## **REQUEST FOR ADDITIONAL INFORMATION – SSD 7919 MOD 2**

This submission has been prepared by Ethos Urban on behalf of Loreto Kirribilli, in response to the Request for Additional Information (RFI) issued by the Department of Planning, Industry and Environment (the Department) on 22 June 2020, relating to SSD 7919 MOD 2. SSD 7919 MOD 2 seeks approval for internal and external design amendments and the installation of a substation.

West Elevation - Reduced S4.55 Plant
1:100

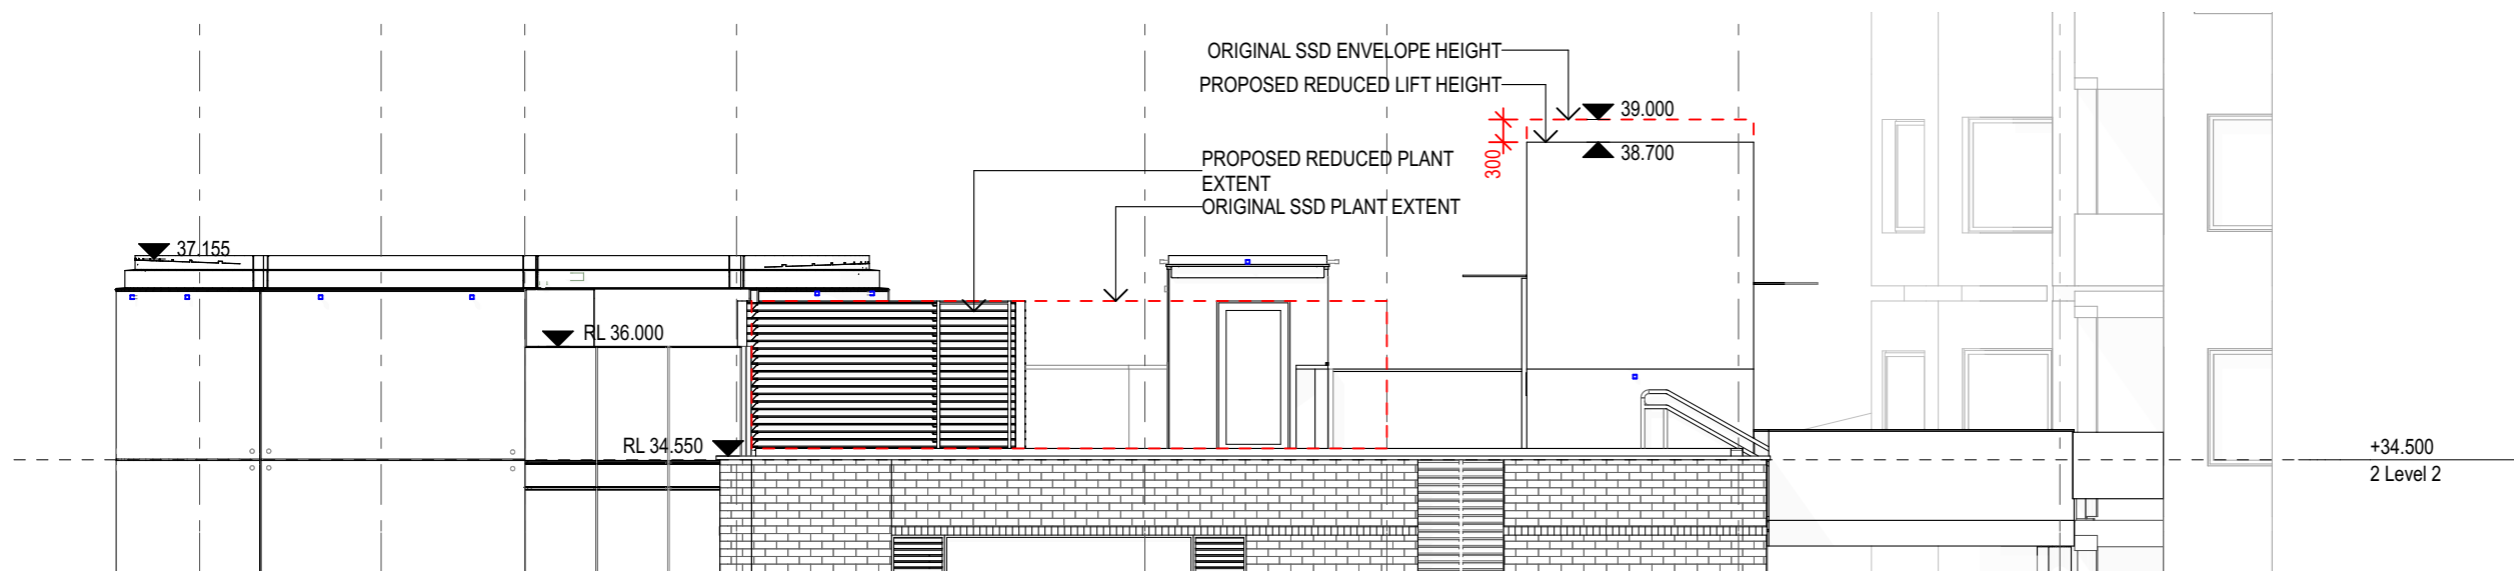
Item and Description	Response
<b>DPIE Issues Letter RFI items</b>	
The Department raises strong concerns that the proposed changes to the materiality of the lift overrun (from a transparent glass to concrete) would result in an adverse impact on the sky views enjoyed by the residents on the western side of the site (at 111 Carabella Street).	<p>In response to DPIE's comments, FJMT has prepared a statement to support the proposed change in materiality from glazing to off form concrete (<b>Attachment A</b>).</p> <p>The development, as proposed to be modified, will result in significantly improved views from apartments to the west of the site, notwithstanding the proposed change in lift materiality.</p>
The Department's view impact assessment of the original proposal concluded that the transparent material of the lift overrun would assist in retaining the visual permeability and sky views for the affected neighbours. However, the proposed modification would not result in improving this previously assessed outcome. As a result, the Department considers that the proposed material of the lift overrun should be converted to a transparent material like glass (as previously approved).	<p>The relocation of the kitchen exhaust system and the significant reduction of the mechanical plant on the roof has opened-up this area to provide a greater sense of space and access to northern views towards the water for the neighbours to the west. The height of the lift overrun has also been reduced. As shown in the submitted view analysis (reproduced at <b>Figure 1</b> below), these improvements will greatly enhance the roof top amenity and views across the site from neighbouring apartments when compared to the approved development. This significant reduction in rooftop plant will offset the proposed change in lift materiality.</p> <p>Further, through consultation with the project's façade engineer, it has been advised that completely clear glass would not be achievable due to thermal requirements for the glazing. If the glazing were retained, it would need to have a dark tint or performance film, similar to the sample shown at <b>Figure 2</b>. This, together with the necessary internal structures and equipment would reduce the transparency of the glazing and the visual benefit it offers.</p>

Otherwise further justification should be provided as to why the proposed materiality change would result in a better outcome for the proposal, in terms of the view impacts.	<p>Finally, given the cost of the lift glazing and potential supply chain risks associated with the current circumstances, the revised materiality is considered the most appropriate means of minimising the risk of supply chain delay and potential construction delay and further increase to costs. The concrete finish will be a high quality, off form concrete - FJMT is confident that a high-quality finish can be achieved due to the rectilinear lift form (refer to example at <b>Figure 3</b>).</p> <p>Whilst it is acknowledged that the concrete lift overrun will not achieve the same level of transparency as clear glazing, the originally intended transparency is not possible due to the need for the glass to be tinted for thermal performance. Further, the proposed modification will see the extent of rooftop plant significantly reduced, which will improve northern views towards the water from neighbouring apartments, providing benefits beyond what would be achieved by the glass lift overrun.</p>
